DEPARTMENT OF PLANNING AND DEVELOPMENT

August 25, 2004

RE: 52 Center St. (038 E012)Waiver request

ELEVATIONS

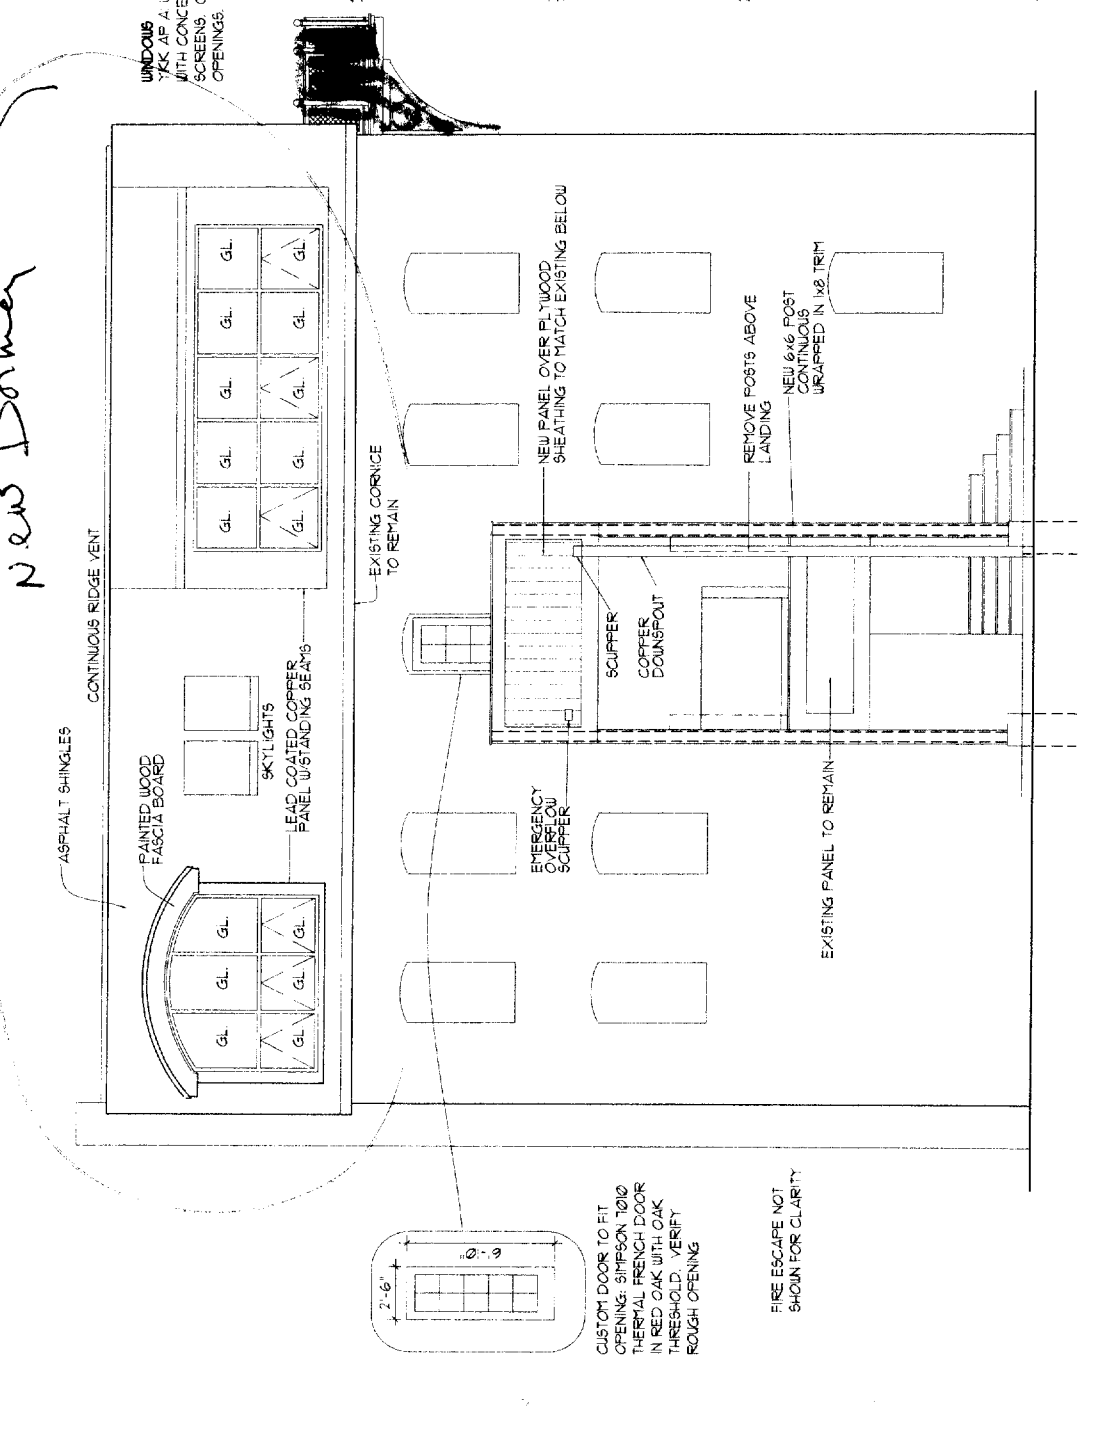
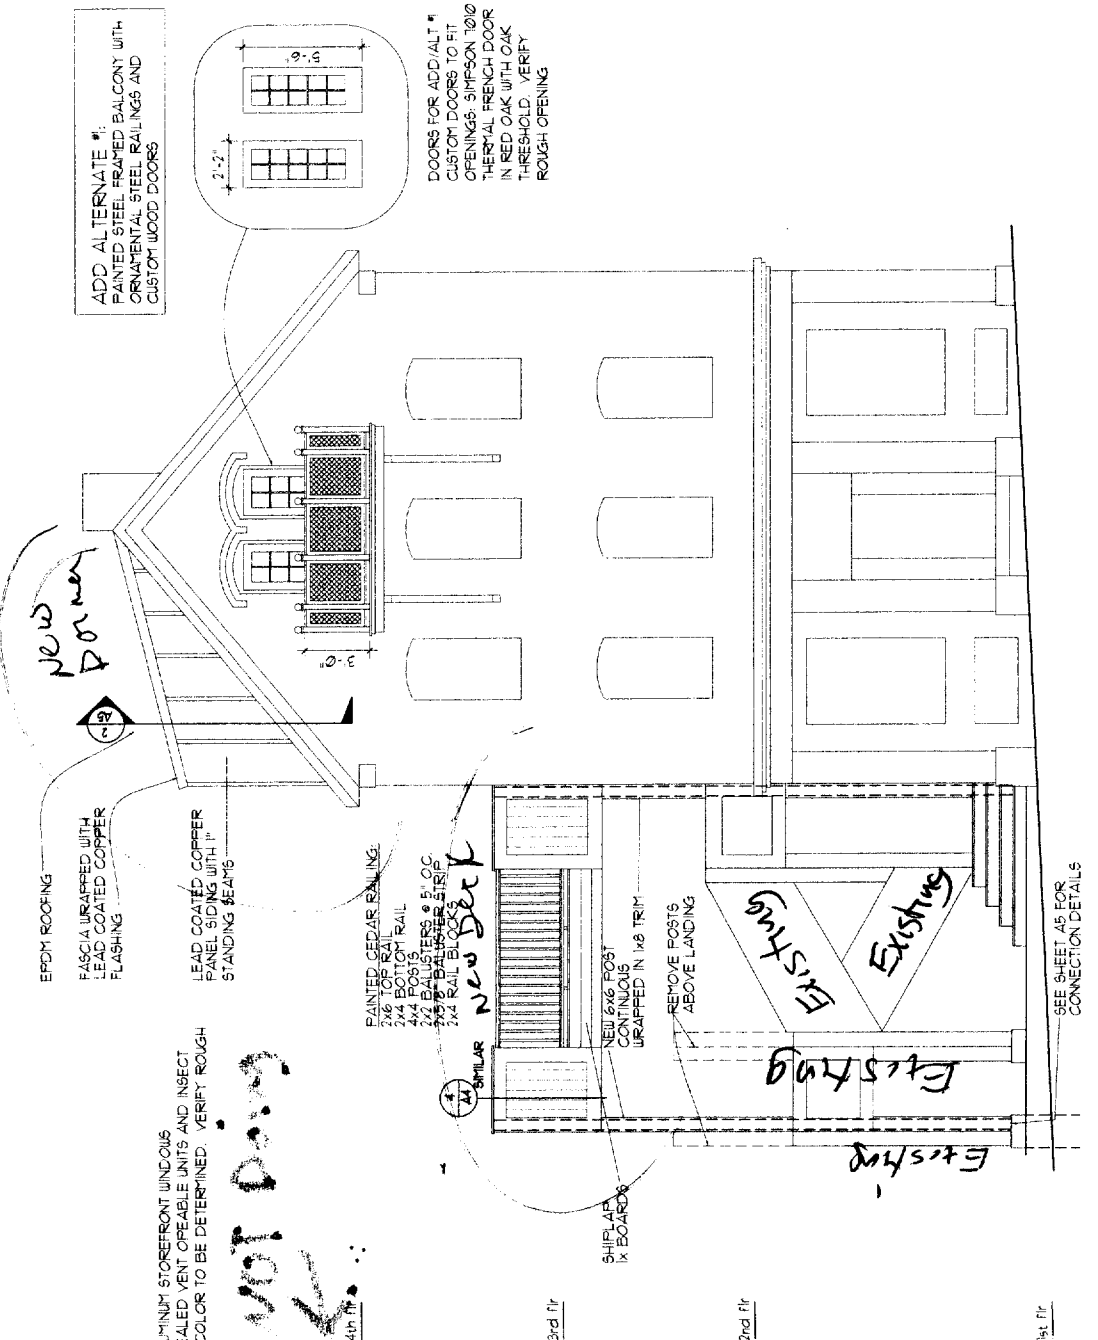
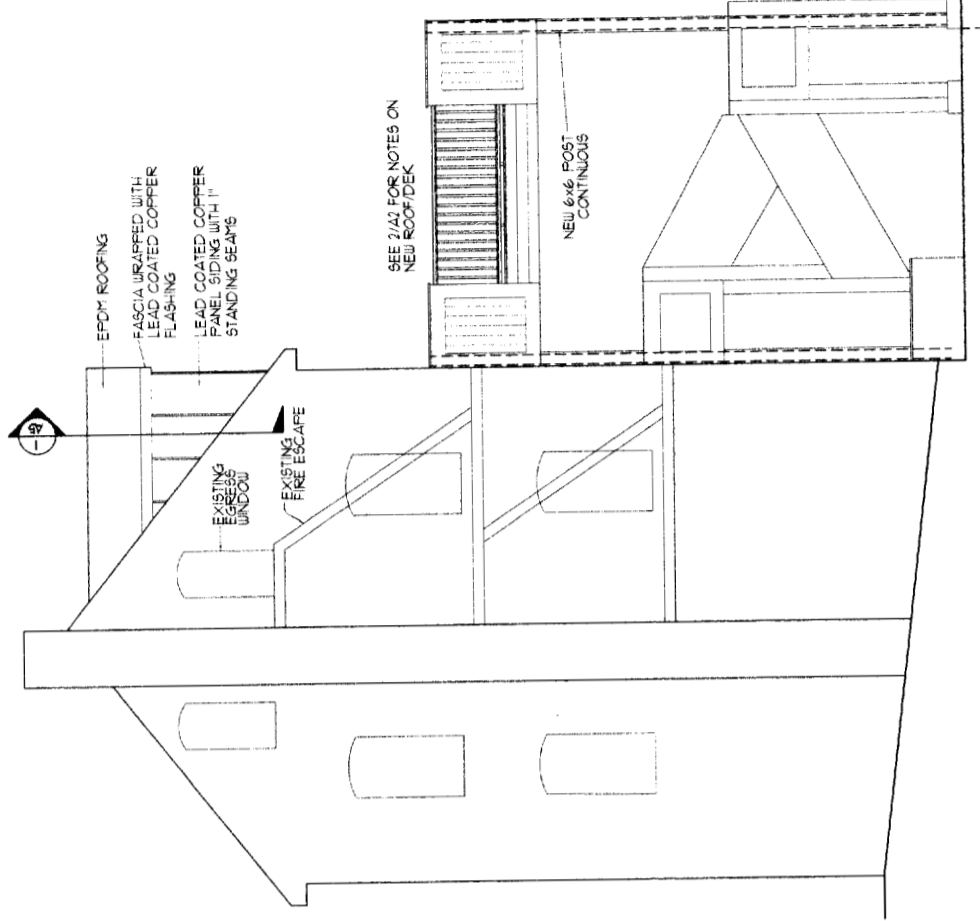
The waiver requested for the installation of openings (windows) in the South wall of the structure. The applicant proposes that the City consider the entire surface of the south wall in calculating the percentage of unprotected openings. This distance from the surface to the lot line is 16 feet. The applicant proposes that although the top floor has a 74.8% openings, the overall wall surface is 21% The space will be protected with a limited Fire Suppression System. Based on the above increase in fire rating and the total percentage of unprotected openings and the actual distance to the abutting structure, this office grants the waiver of the requirements of Section 705.3 and 705.3.2 pursuant to Section 121 of the City Building Code as amended.

I, Daniel Steele, agree, as a condition of approval, that, in the event of future development of the abutting parcel in a manner that brings buildings closer than 30 feet to the south wall of the subject building, The South wall of 52 Center St. will be made to conform to building code provisions in effect at the time of this activity that limit openings based on Fire separation distance.
